Highways England Planning Response (HEPR 16-01) Formal Recommendation to an Application for Planning Permission

Council's Reference: 21/0200

Referring to the notification of an outline planning consultation dated 8th March 2021 for prior approval for the installation of a 20 metre high telecommunications monopole supporting 6 antennas and 2 transmission dishes including 4 equipment cabinets at base and associated ancillary works pursuant to Schedule 2 Part 16 of the Town and Country Planning (General Permitted Development) (England) Order 2015 (as amended) on land at the junction of the A585 Trunk Road, the A586 Garstang Road and Windy Harbour Road, Little Ecclestone-with-Larbreck FY6 8ND, Highways England's formal recommendation is that we:

Title: **215 PROPOSED SITE PLAN**

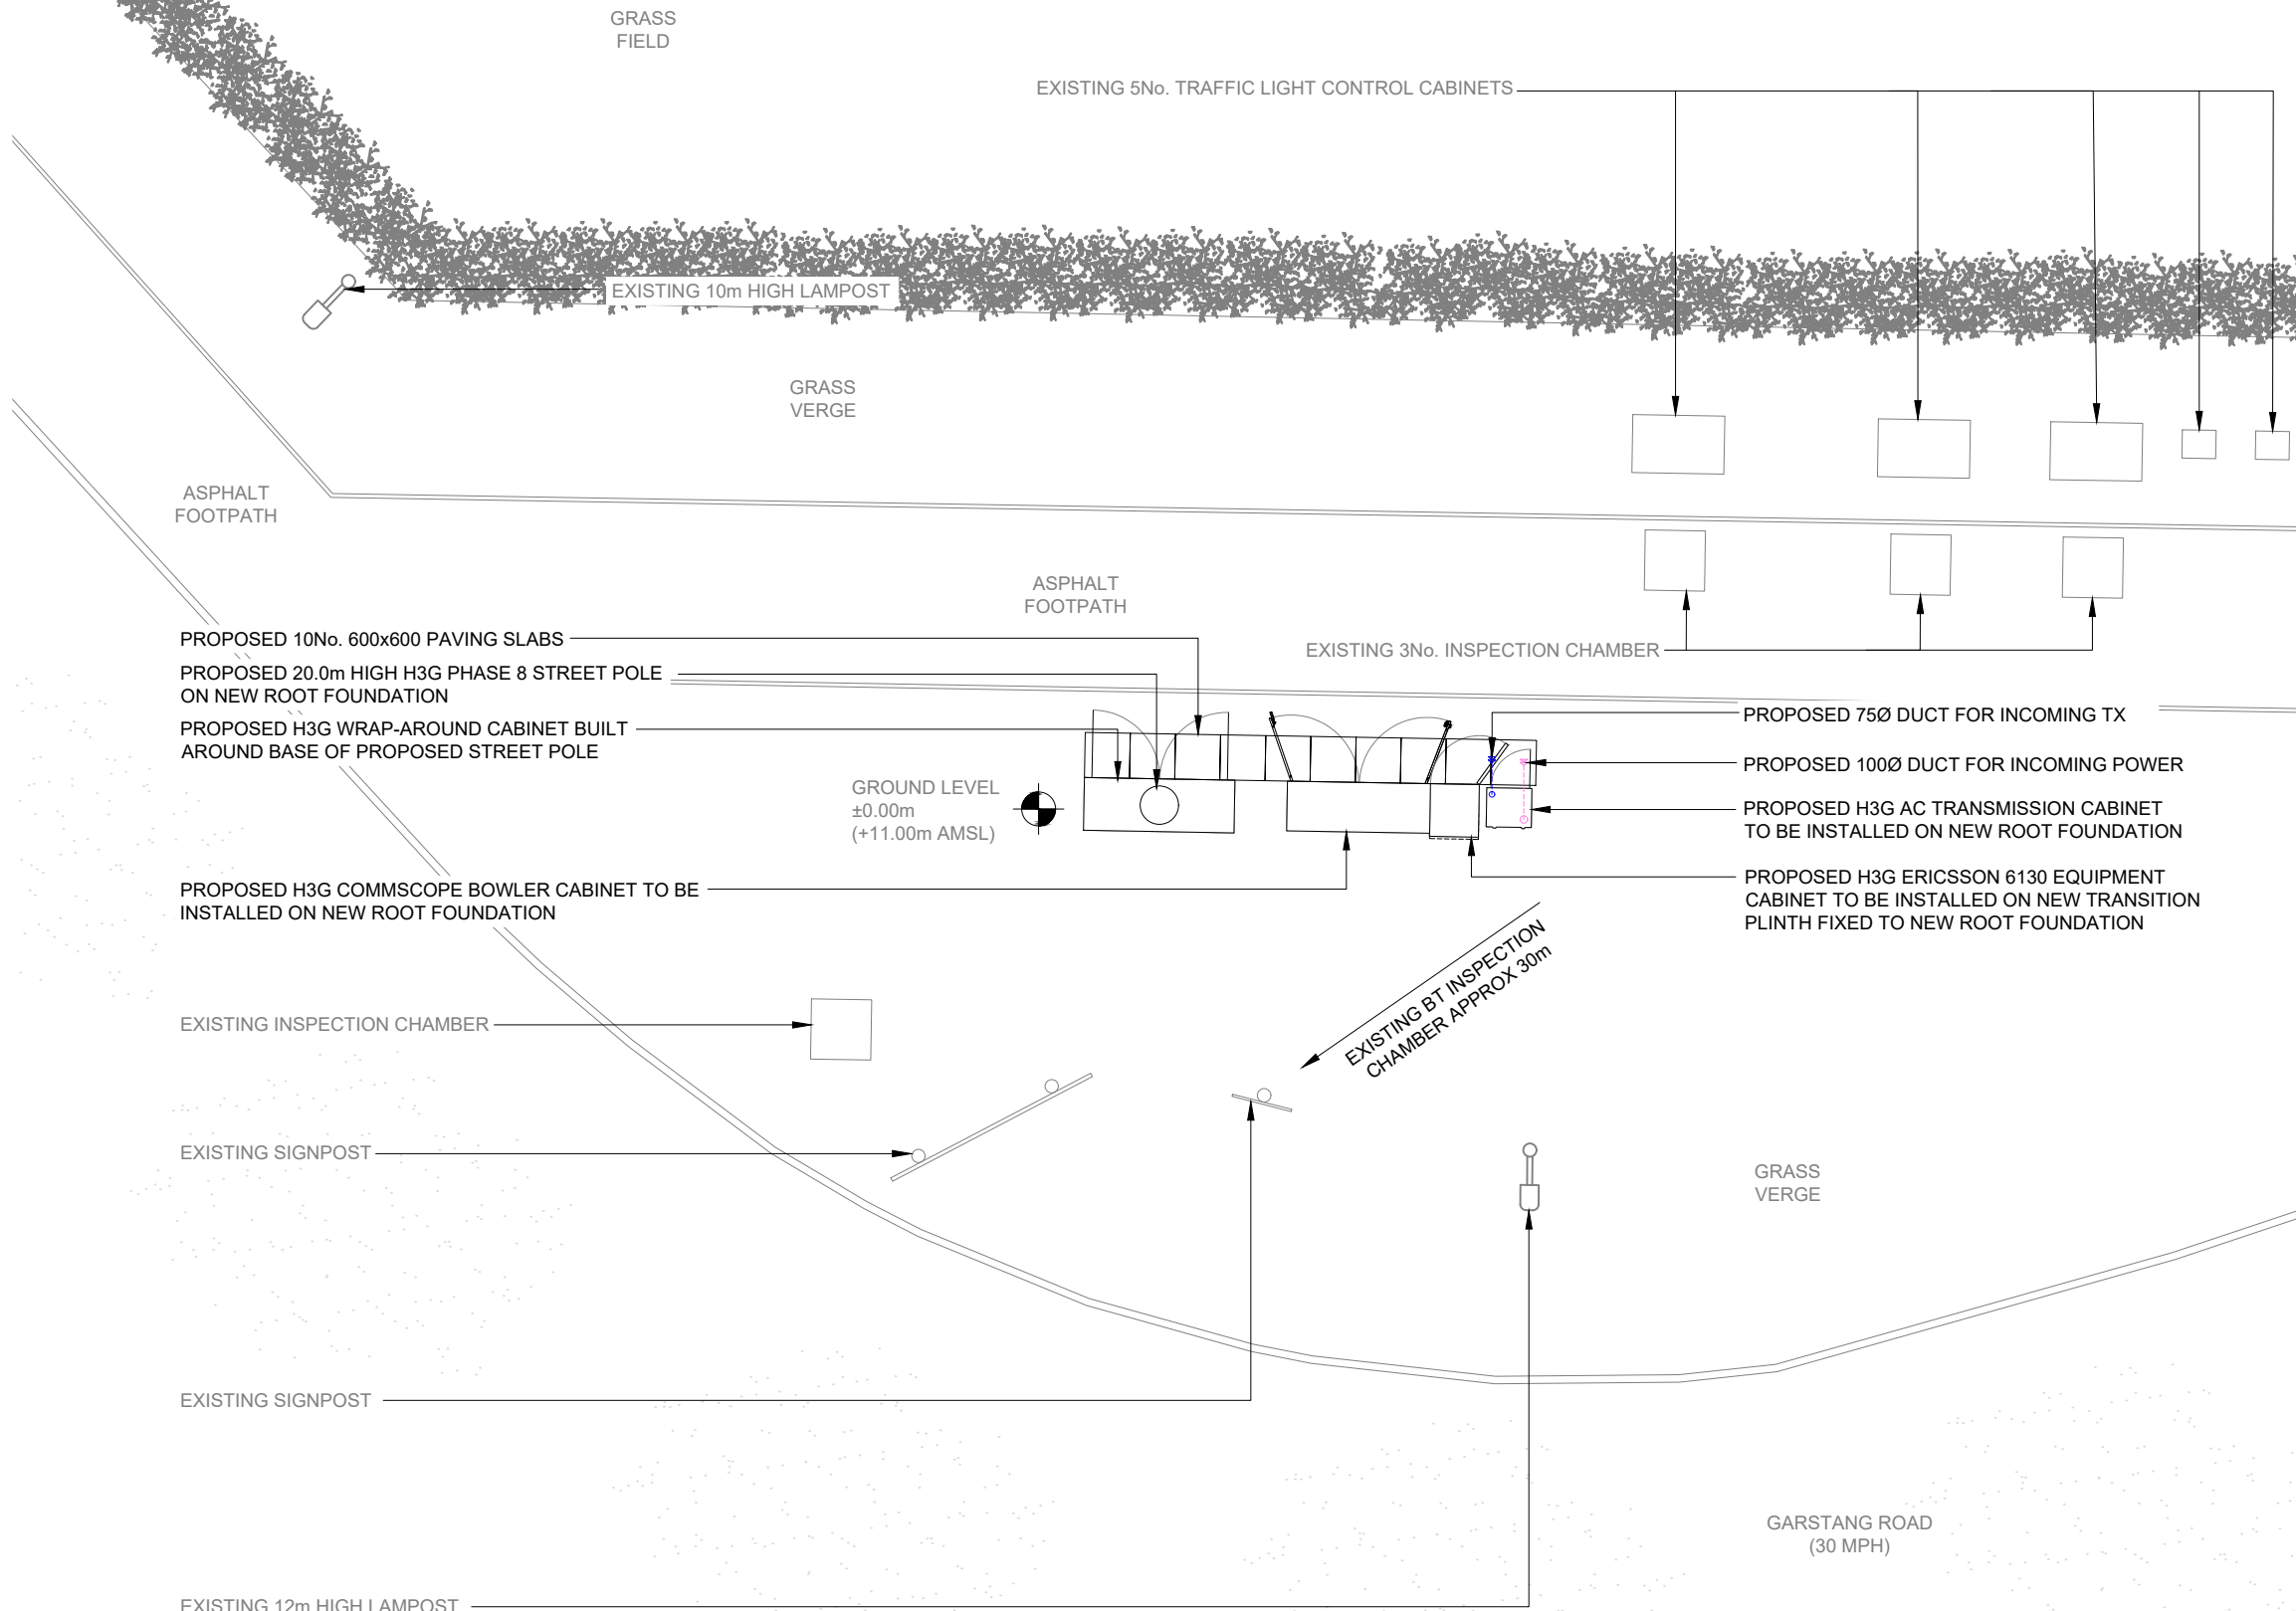
The proposal would see the installation of a 20 metre high monopole supporting 6no. antennas, 4no. equipment cabinets and development works on highway verge on the north-eastern corner of the Windy Harbour junction; a busy signalised junction that will from 2023 serve as the gateway to a new dual carriageway section of the A585 (currently under construction). The development would also be on land owned by Highways England.

Highways England’s prime concern is safety. The location of the proposed monopole and cabinets means that the structure is vulnerable to being hit by errant vehicles at the junction in loss of control incidents. Besides creating an additional potential roadside hazard there is also the possibility that the monopole structure could subsequently topple over in a collision. No consideration appears to have been given to installation of a safety barrier protection of the monopole.

- Undertake a Stage 1 Road Safety Audit (RSA) in accordance with the requirements of standard ‘GG119 – Road safety audit’ of the Design Manual for Roads and Bridges.
- Provide design details of the proposed monopole and seek formal technical approval in accordance with the requirements of standard ‘CG 300 - Technical approval of highway structures’ of the Design Manual for Roads and Bridges.
